**KIRKLEES METROPOLITAN COUNCIL
INVESTMENT & REGENERATION SERVICE**

**DELEGATED DECISION TO DETERMINE APPLICATIONS FOR
CONSENT, AGREEMENT OR APPROVAL REQUIRED BY CONDITION**

Reference No: 2020/44/91468/E

Site Address: Former North Bierley Waste Water Treatment Works,
Oakenshaw, BD12 7ET

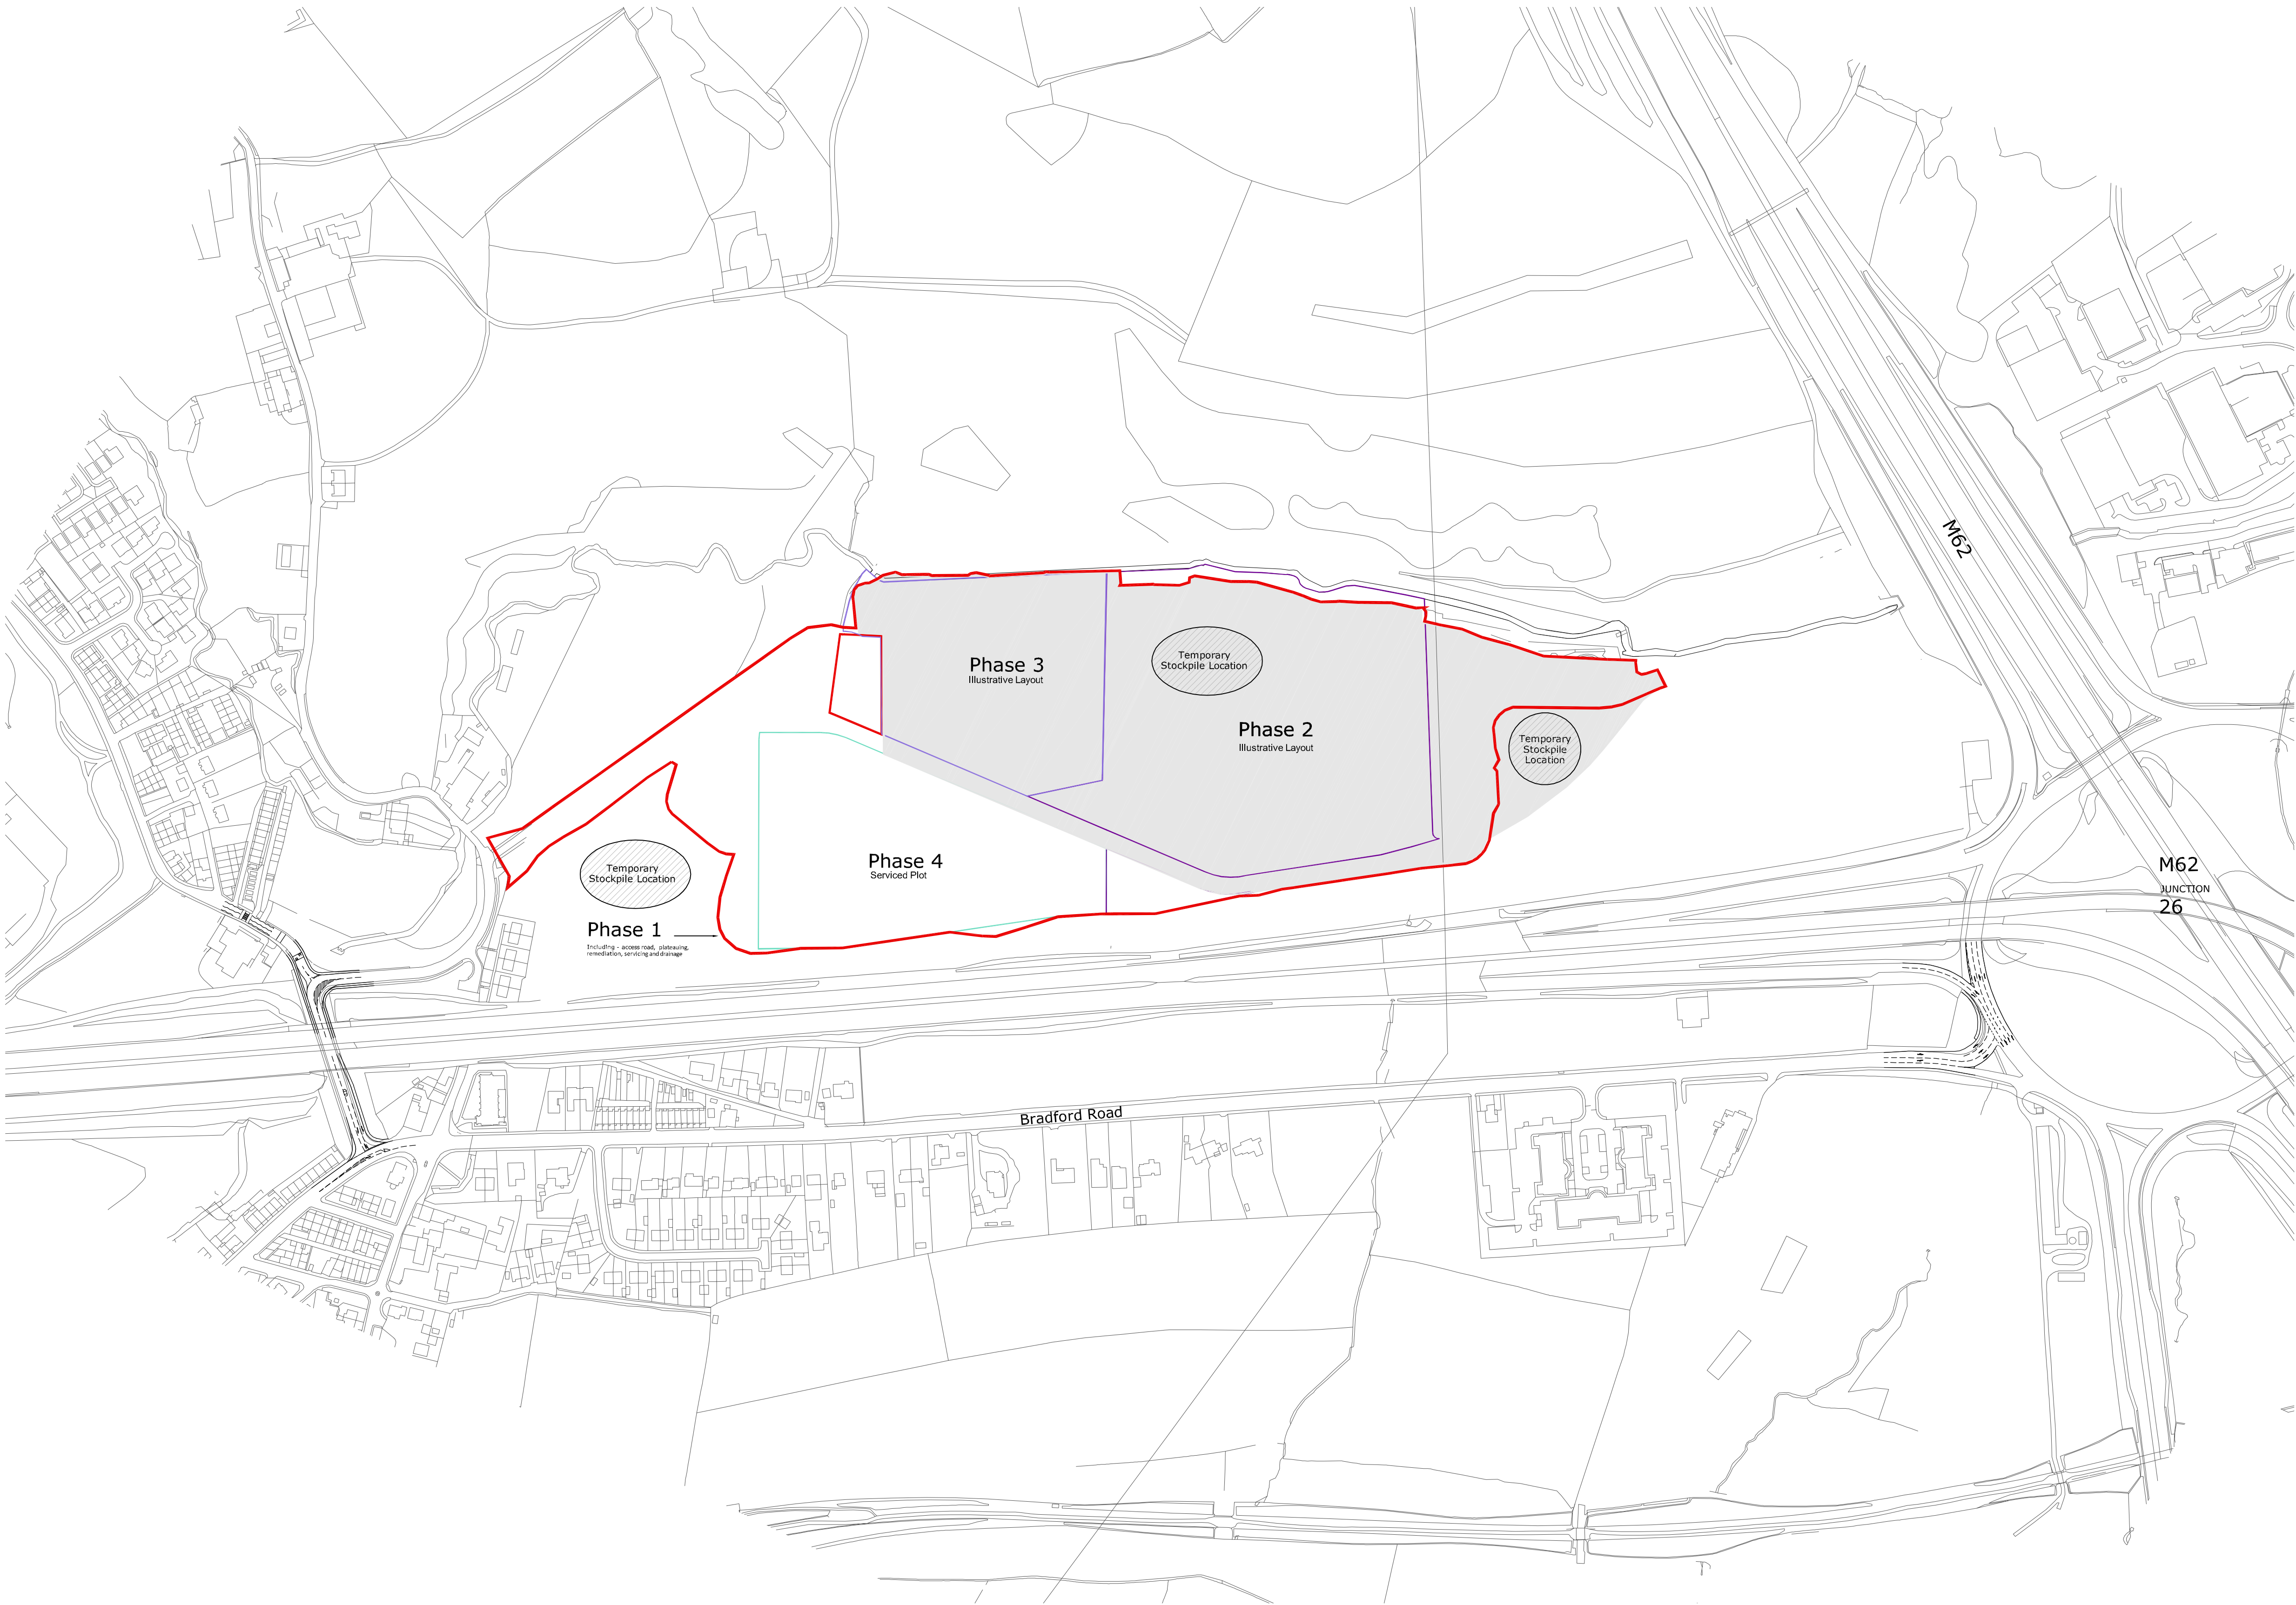
The phasing plan was revised in the course of the application to specifically incorporate a demolition phase (Phase 0). The applicant has therefore submitted Plan 1856 PL 150E received 7th August 2020 in order to discharge Condition 5. The phasing plan clearly identifies the future phases of development to comprise 5 phases:

The submitted phasing plan is clear and comprehensive in setting out how the development of this site will come forward the purpose of ensuring that the development proceeds in an appropriate phased manner. Condition 5 is therefore discharged for the whole site subject to advice that to secure full

compliance with Condition 5, the development shall be carried out and completed in accordance with the phasing plan 1856 PL 150E received 7th August 2020.

1:100yr+CC FLOOD EXTENTS, TWL 96.68m AOD

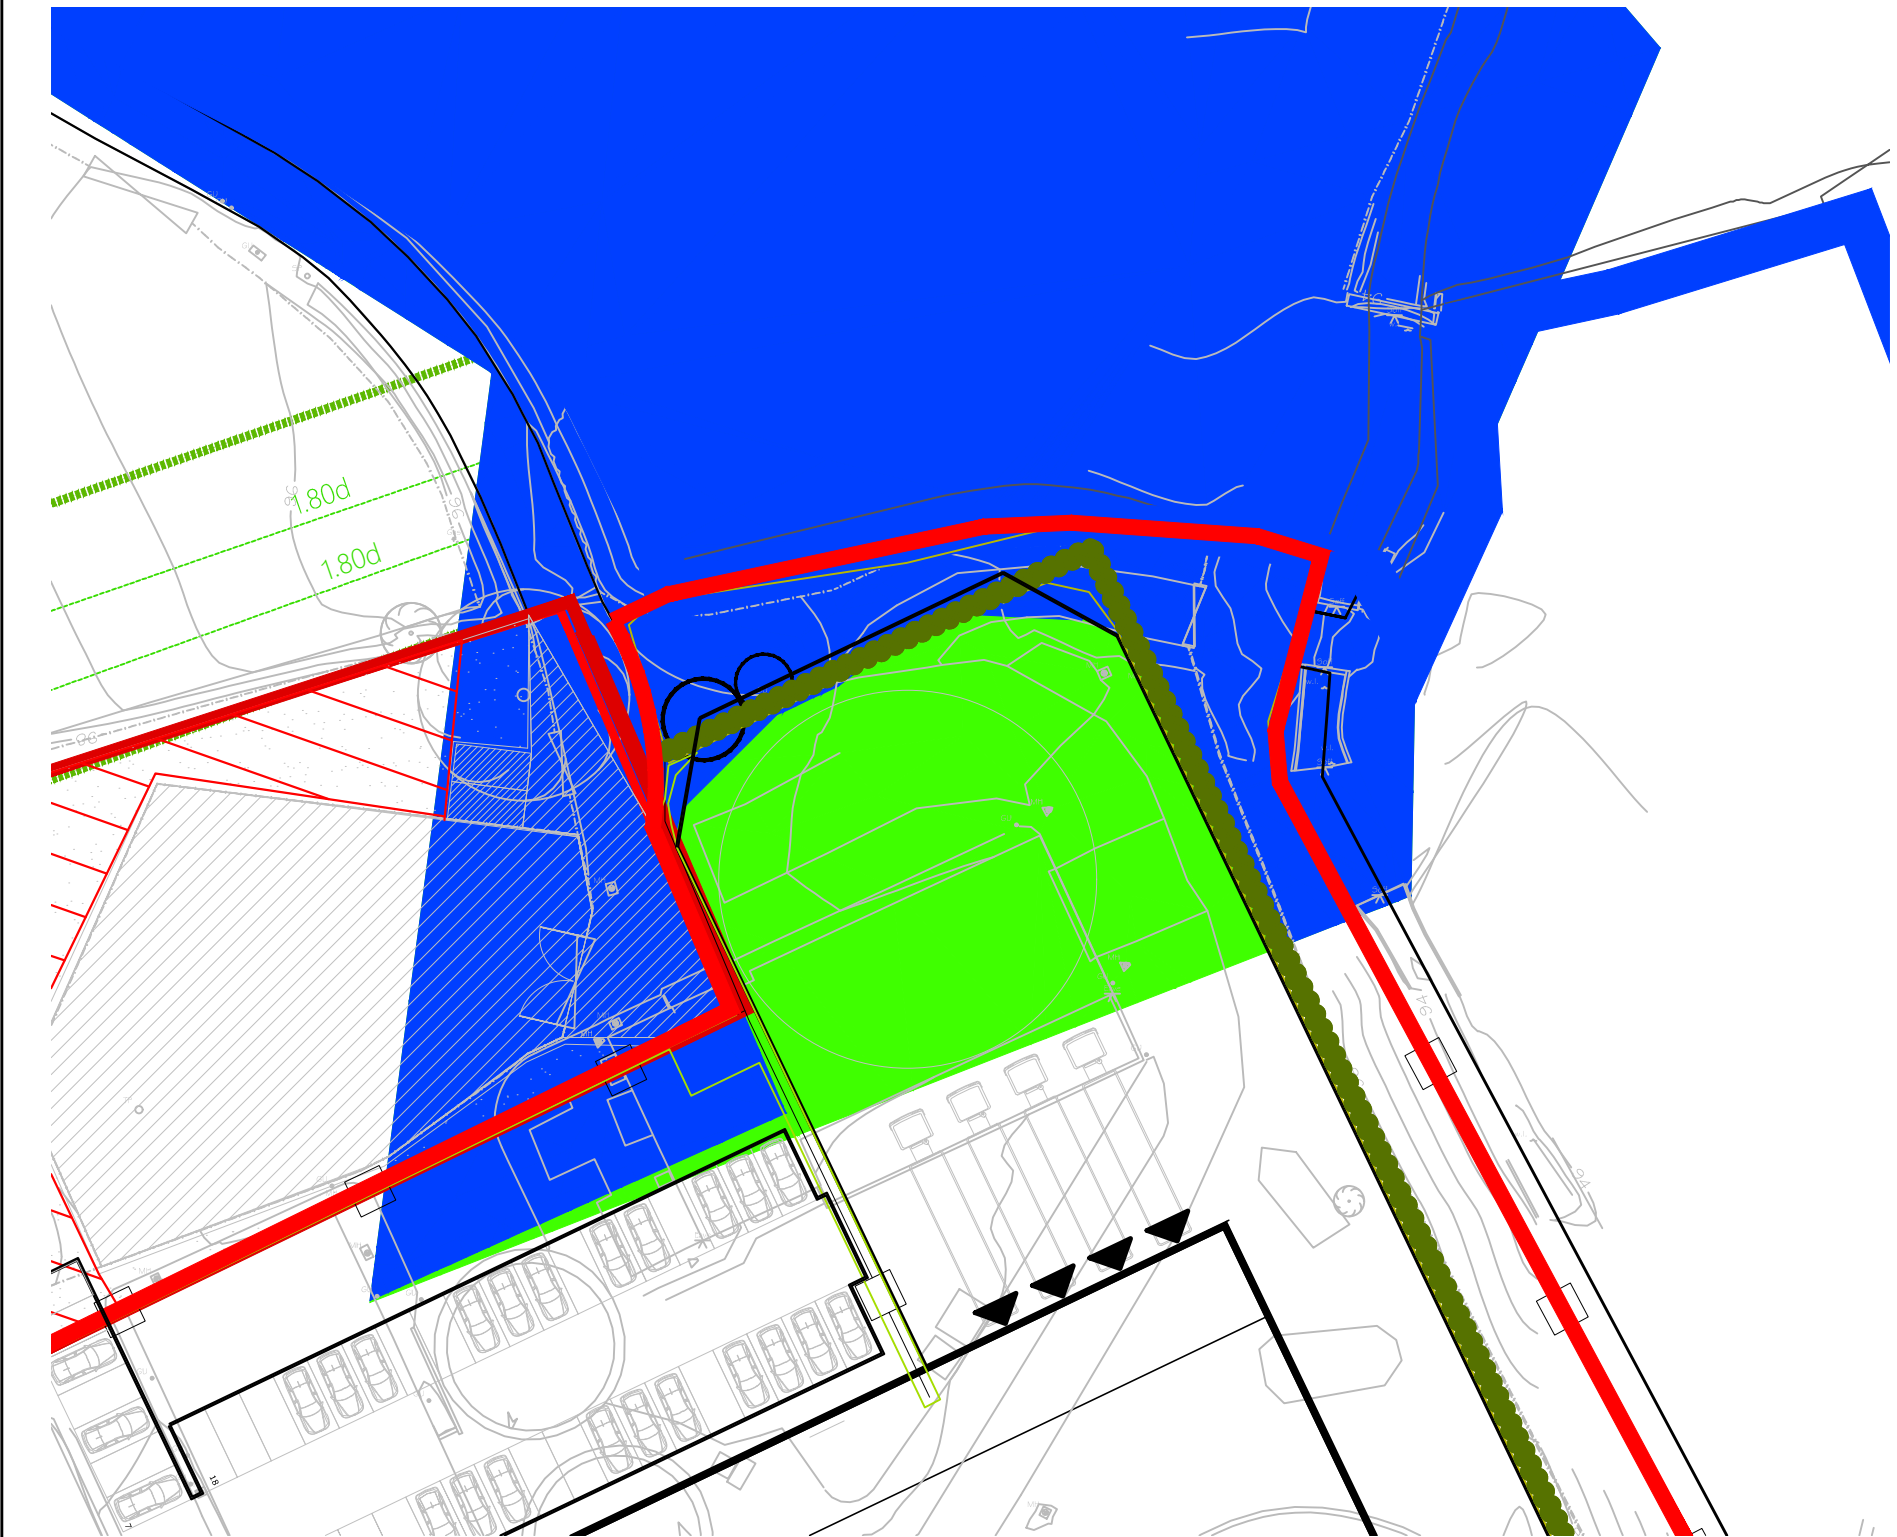
The LLFA initially responded to the original submission to state that no information had been provided within the documents submitted as part of this discharge of condition to demonstrate that flood risk has been satisfactorily incorporated. No updated information has been provided to demonstrate validation of the inflow hydrographs. In 2016, the Modelling report stated that there was no monitoring on the watercourse. Investigation did show that there was an EA model downstream of the motorway culvert that could be used to compare the discharge hydrograph from this model, against the inflow hydrograph to the EA model. The applicant did not provide details of the flood evacuation plan and routes within this submission.

However, over the course of the application, the applicant provided the additional information detailed above. Subsequently, the LLFA confirmed by email dated 24th November that as part of assessing displacement, the applicant has used the 1 in 1000-year flood depth and provided a displacement allowance for this within what was previously proposed to be an attenuation pond. The modelling report provided shows that the modelling uses standard approaches for 1D modelling, with a stated limitation being the incoming hydrology. As the exceedance storage volume exceeds the potentially displaced 1 in 1000-year event, this demonstrates that the proposed development should not adversely impact third parties by passing increased flows downstream. The presence of this pipe may also alleviate issues of displacement from the existing roadway during lower order events.

The exceedance storage is proposed to be connected to the watercourse by a 300mm diameter pipe, the maintenance of this system could be a significant burden long term. Therefore, as part of further phases management and maintenance agreements will need to be put in place for this pipe infrastructure. Kirklees LLFA have no objection to a 300mm pipe but would prefer a larger pipe diameter if possible be installed. During Phase 2 preparation, it may be possible to reduce the cost implications of this design by refining the modelling work undertaken to allow 2D-1D representation and scale back the conservative allowances provided within this design proposal. However, for the purposes of Phase 1, these details are acceptable.

Condition 23 is therefore discharged for Phase 1 subject to advice that to secure full compliance with the condition, Phase 1 shall be implemented in accordance with these approved plans and details.

It is recommended that the 300mm pipe is subject to a monthly inspection or after each heavy rain event to ensure that it is kept clear of debris.
